A46 Newark Bypass

Scheme Number: TR010065

Statement of Common Ground with Nottinghamshire County Council

**Statement of Common Ground with
Nottinghamshire County Council**

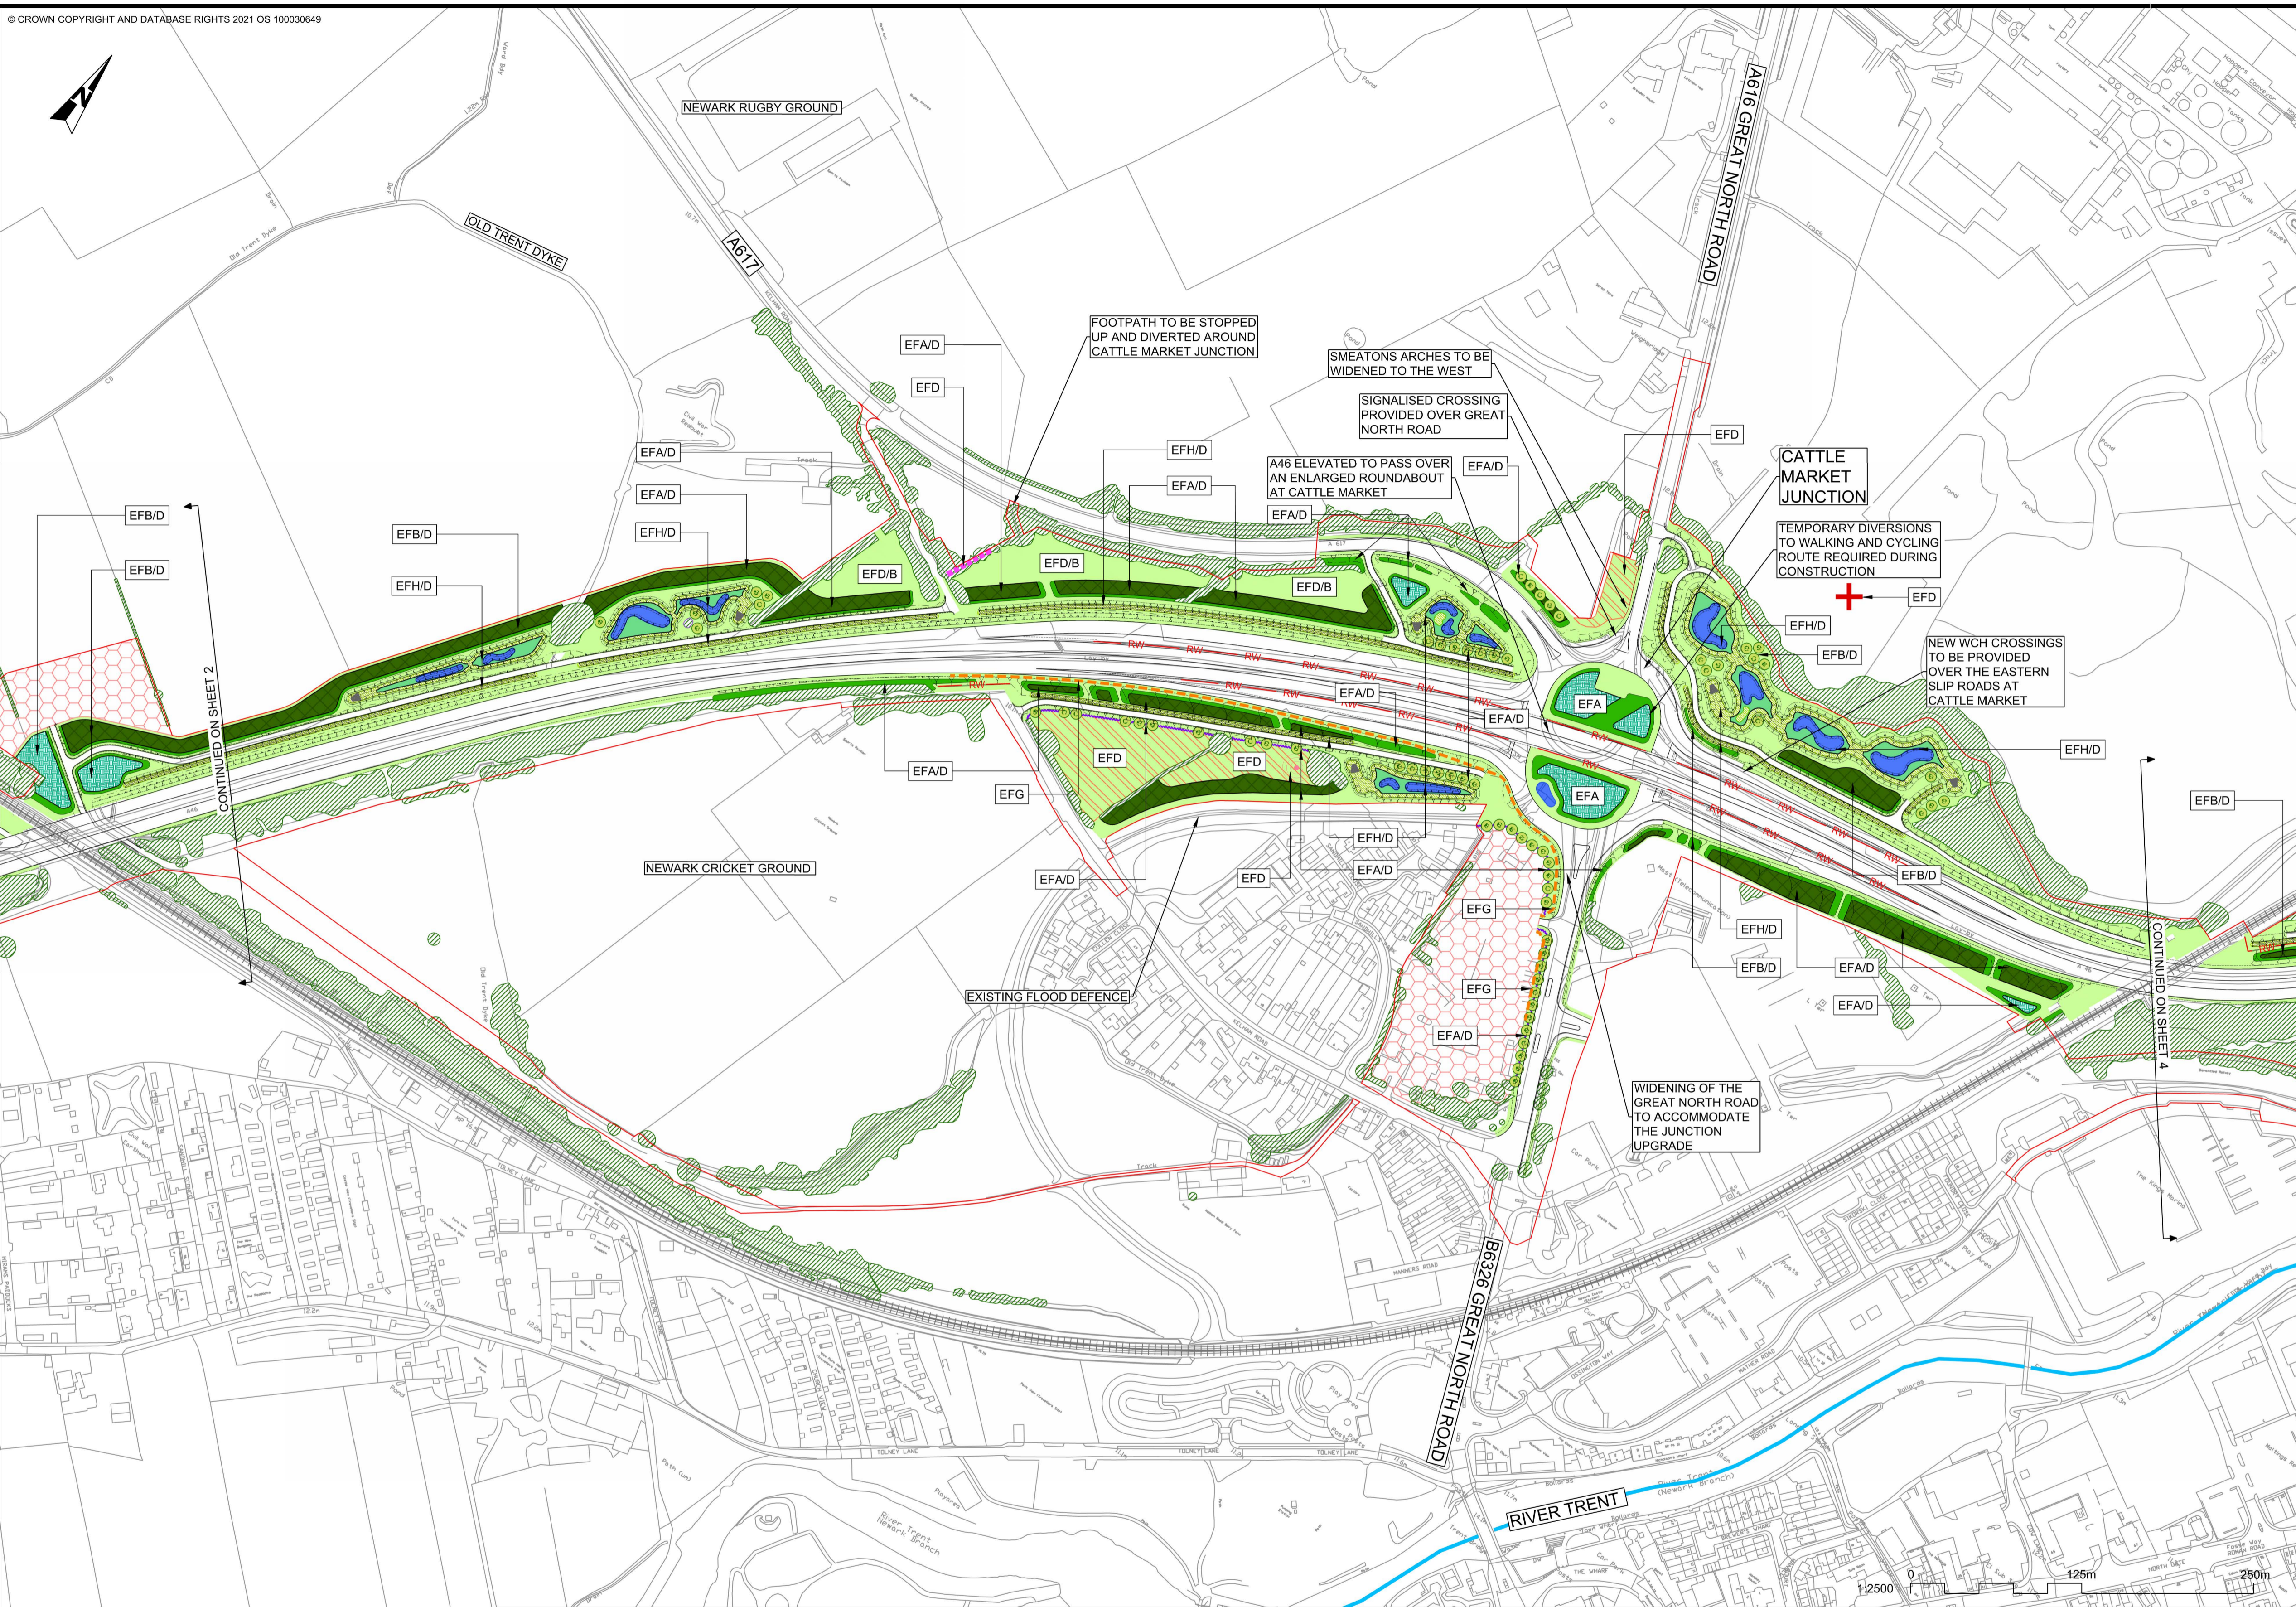
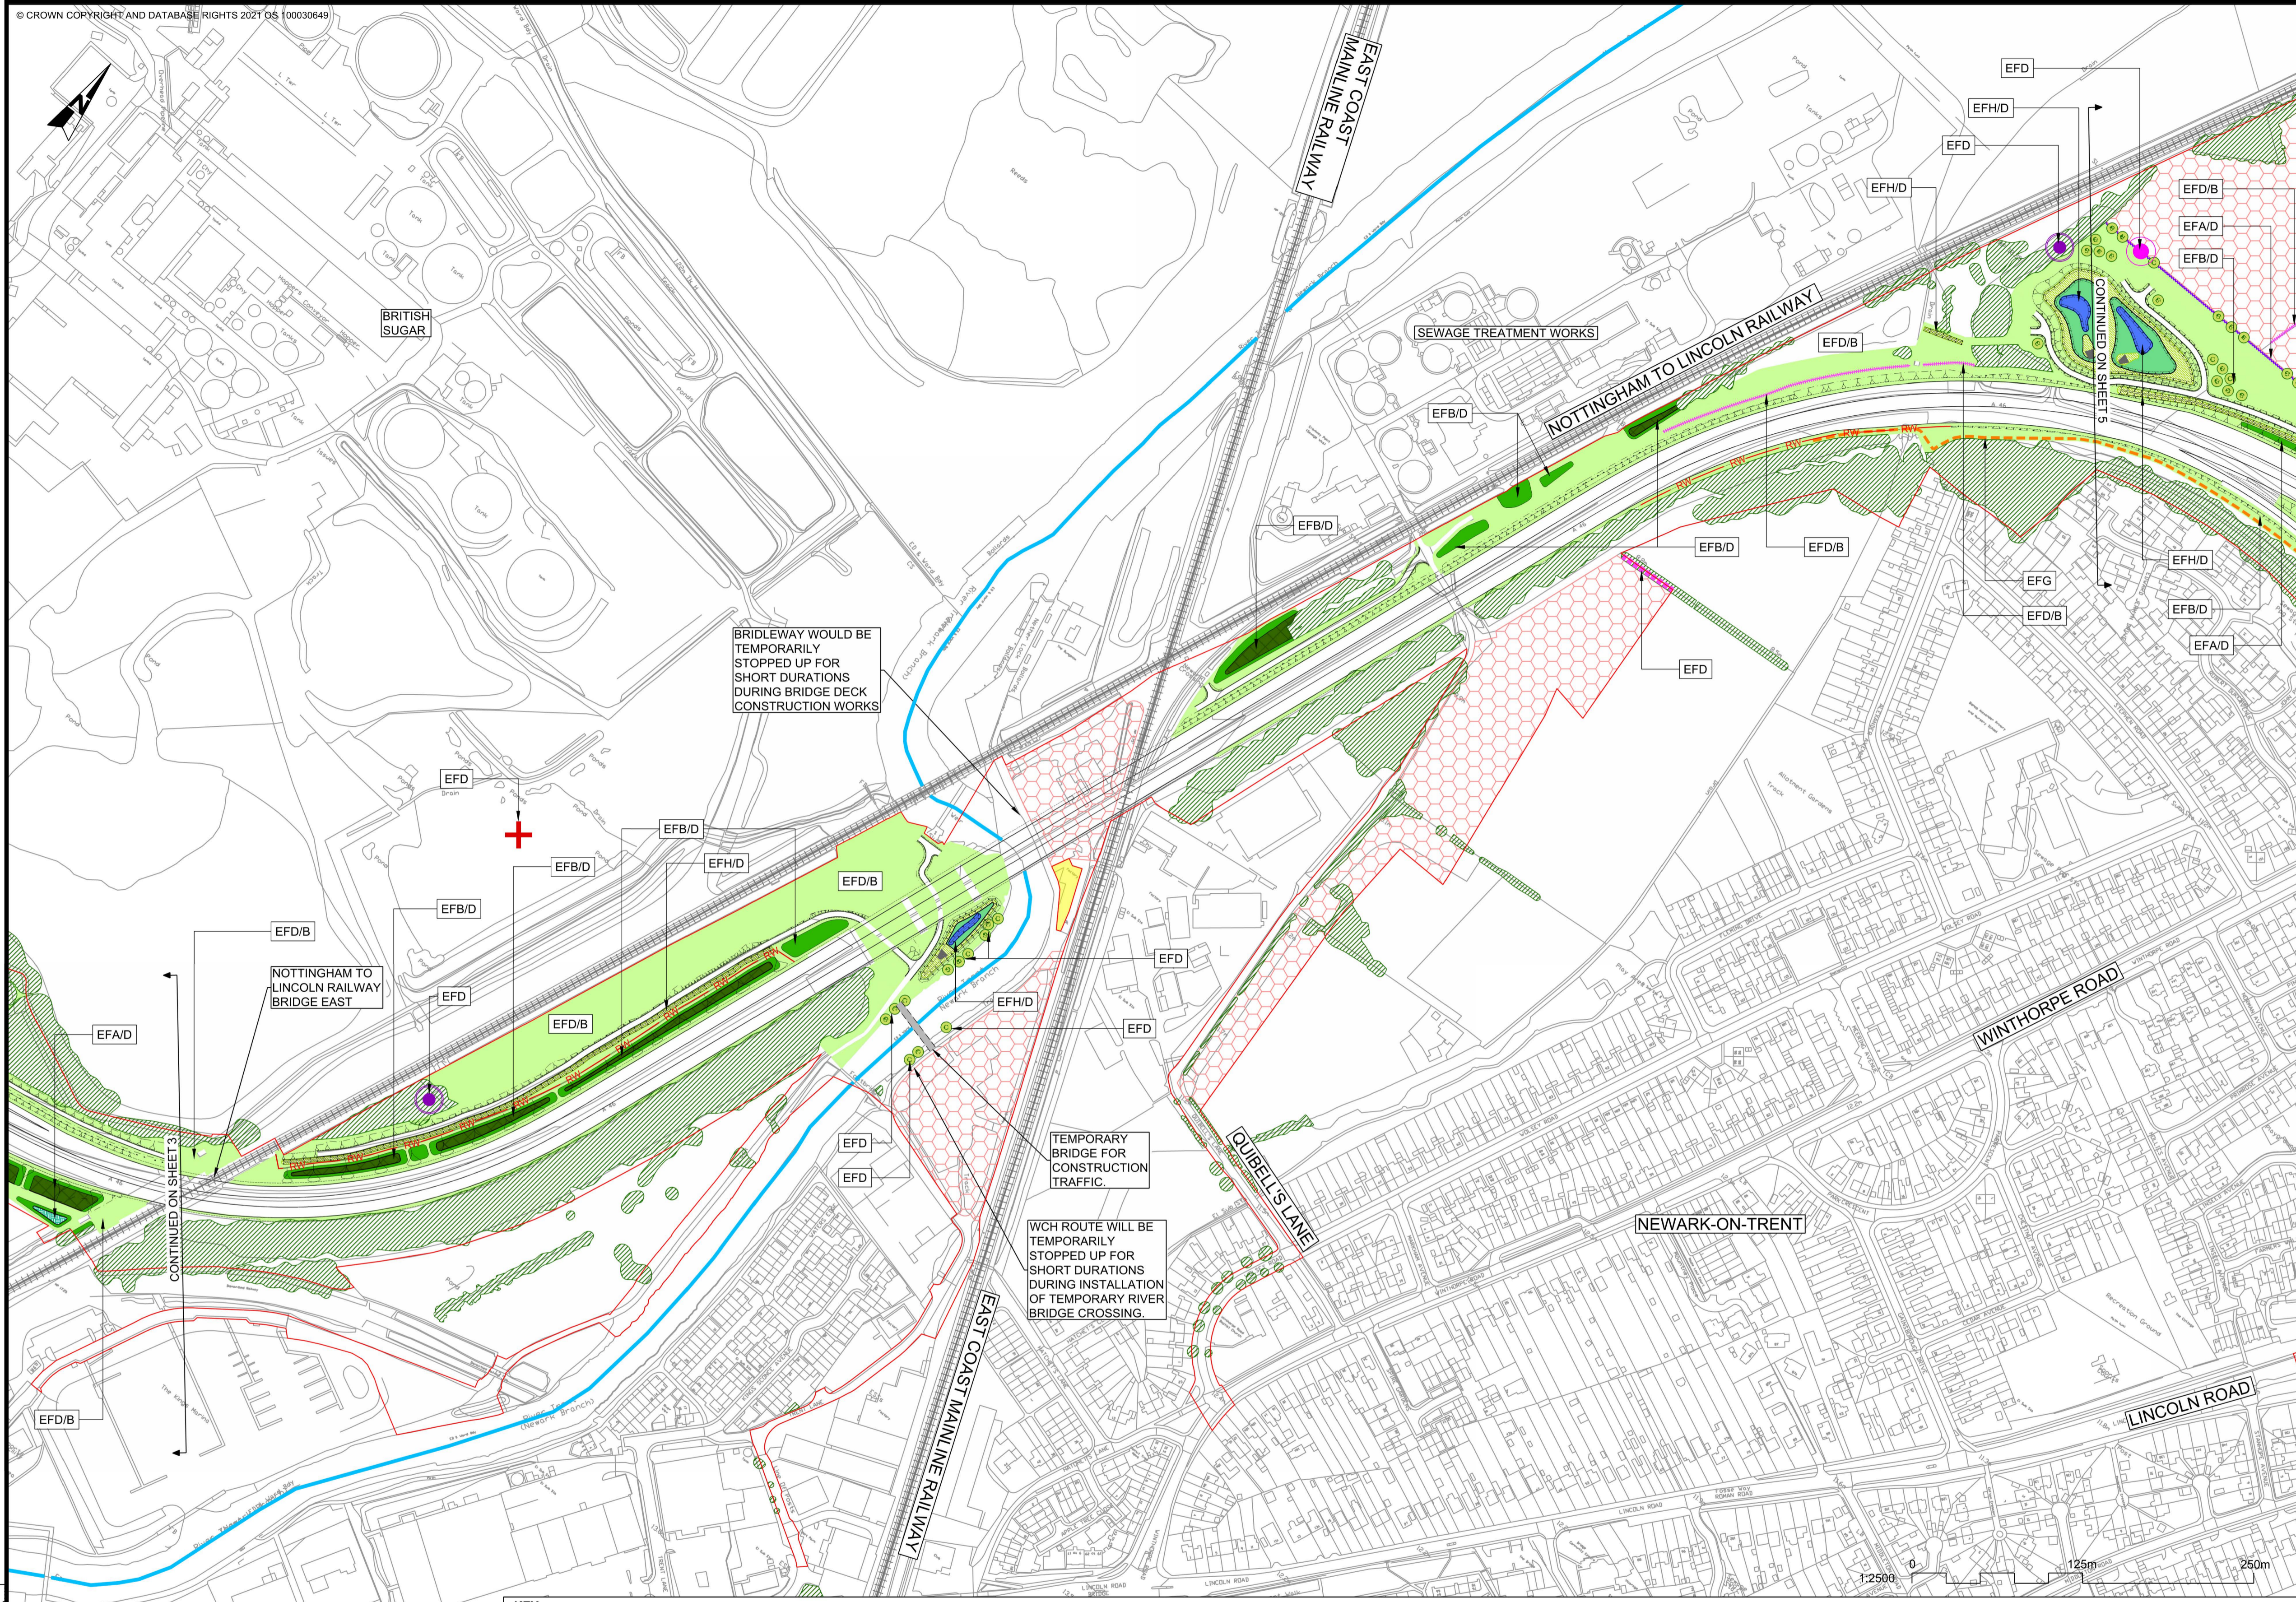
21.	Ecology (biodiversity)	6.2 Environmental Statement - Figure 2.3 Environmental Masterplan [AS-026] 6.2 Environmental Statement - Figure 8.4 - Planting for Loss of Local Wildlife Site Habitats [AS-045] 6.3 Environmental Statement - Appendix 8.1 Extended Phase 1 Habitat Technical Report Part 1 [APP-145] & Part 2 [APP-146] 6.1 Environmental Statement - Chapter 8 Biodiversity [APP052] 6.3 Environmental Statement - Appendix 8.2 National Vegetation Classification Technical Report [APP-147].	<p>Attenuation pond locations</p> <p>The Scheme will inevitably lead to the loss of Local Wildlife Site habitat contained within the Great North Road Grasslands LWS 2/778 at the Cattle Market junction. Unfortunately, these losses are compounded by the location of attenuation basins within two parts of this LWS. Given that there appear to be other places within the DOL boundary in the immediate vicinity of the junction which are not covered by LWS designation, the attenuation basins should be moved to minimise impacts on designated sites caused by the scheme and correctly apply the mitigation hierarchy (i.e. by avoiding impacts in the first instance)</p> <p>Relating to the Environmental Information report</p> <p>Para. 9.5.9</p> <p>National Vegetation Classification (NVC) surveys should also be undertaken of affected LWS grasslands (recognising that some may have declined in quality and therefore no longer be 'good quality semi-improved grassland', but it will be important that this can be evidenced).</p>	<p>Re-locating the basins outside of the Local Wildlife Site would require direct run-off against the natural fall of the land as well as the highway, which in turn would lead to piped runs at unrealistic depths or swales having to be raised higher to allow flows to be conveyed towards the basin. The basins are therefore still proposed within the Local Wildlife Site but have been developed to ensure nature-based solutions are maximised wherever practicable. A compensation package has been designed to provide the equivalent habitat type to that lost within each Local Wildlife Site, details of which can be found in 6.2 Environmental Statement - Figure 2.3 Environmental Masterplan [AS-026] and 6.2 Environmental Statement - Figure 8.4 - Planting for Loss of Local Wildlife Site Habitats [AS-045].</p> <p>Habitats within the Scheme study area were initially identified, classified and mapped in accordance with the Joint Nature Conservation Committee's <i>Handbook for Phase 1 Habitat Survey</i>. The habitats identified are detailed within Appendix E of 6.3 Environmental Statement - Appendix 8.1 Extended Phase 1 Habitat Technical Report Part 1 [APP-145] & Part 2 [APP-146] and 6.1 Environmental Statement - Chapter 8 Biodiversity [APP052]. Habitats identified during the Phase 1 habitat survey as potential Priority Habitats and any Local Wildlife Site habitats (including grasslands) were subsequently subject to a National Vegetation Classification survey to confirm the habitat classification against the Local Wildlife Site citation 6.3 Environmental Statement - Appendix 8.2 National Vegetation Classification Technical Report [APP-147]. The following communities were found to be present within the survey area; MG1, MG4, MG5, OV26, W8 and W10. Where appropriate, all accessible habitats were subject to habitat condition assessments with reference to the <i>Biodiversity Metric 3.1 Technical Supplement (Panks et al., 2022)</i>.</p> <p>A precautionary approach has been taken to assigning condition for baseline habitats where condition was not assessed as part of the Phase 1 Habitat survey / where no National Vegetation Classification surveys were undertaken, due to access constraints. In these cases, the baseline condition was precautionarily assessed as good. This is also applicable to habitats located within all Local Wildlife Sites potentially impacted by the Scheme.</p>	Under Discussion	18/10/2024

26.		6.2 Environmental Statement - Figure 2.3 Environmental Masterplan [AS-026].	<p>New floodplain habitat</p> <p>The borrow pit and floodplain compensation areas provide an opportunity to create new floodplain habitat on at least some of the land identified. With careful design, wet grassland (to include ditches, pools and scrapes) can be created, providing habitat for things like breeding waders and wintering wildfowl, whilst allowing ongoing farming practices through grazing. Marsh and swamp, reedbed and ponds should also be considered. As part of the design, public access should be provided, where possible, in such a way that does not impinge on farming activities or that would lead to disturbance of wildlife.</p>	<p>Farndon East and Farndon West are proposed as floodplain compensation area sites. Farndon West would also provide essential mitigation in the form of habitat creation, enabling multiple benefits. The design principles for these areas are to create highly distinctive habitats that complement local biodiversity whilst also being appropriate to floodplain conditions and allow high confidence in successful establishment. The environmental design for these areas including the essential mitigation measures can be seen on 6.2 Environmental Statement - Figure 2.3 Environmental Masterplan [AS-026].</p> <p>The main habitats within Farndon West floodplain compensation area include a network of ponds and reedbeds surrounded by marsh and wet grassland with individual trees, as well as an area of floodplain grazing marsh, together with fringe areas of species-rich grassland and planting of individual trees. Habitat in the form of marsh and wet grassland around the edges of the lake in Farndon East floodplain compensation area would also be provided. For these areas in particular, public access is not provided in order to maximise the biodiversity value of the areas (reducing stresses presented by public use, such as dog walking) and also to reduce health and safety risks posed by ponds (former borrow pits which would hold standing water).</p>	Under Discussion	18/10/2024
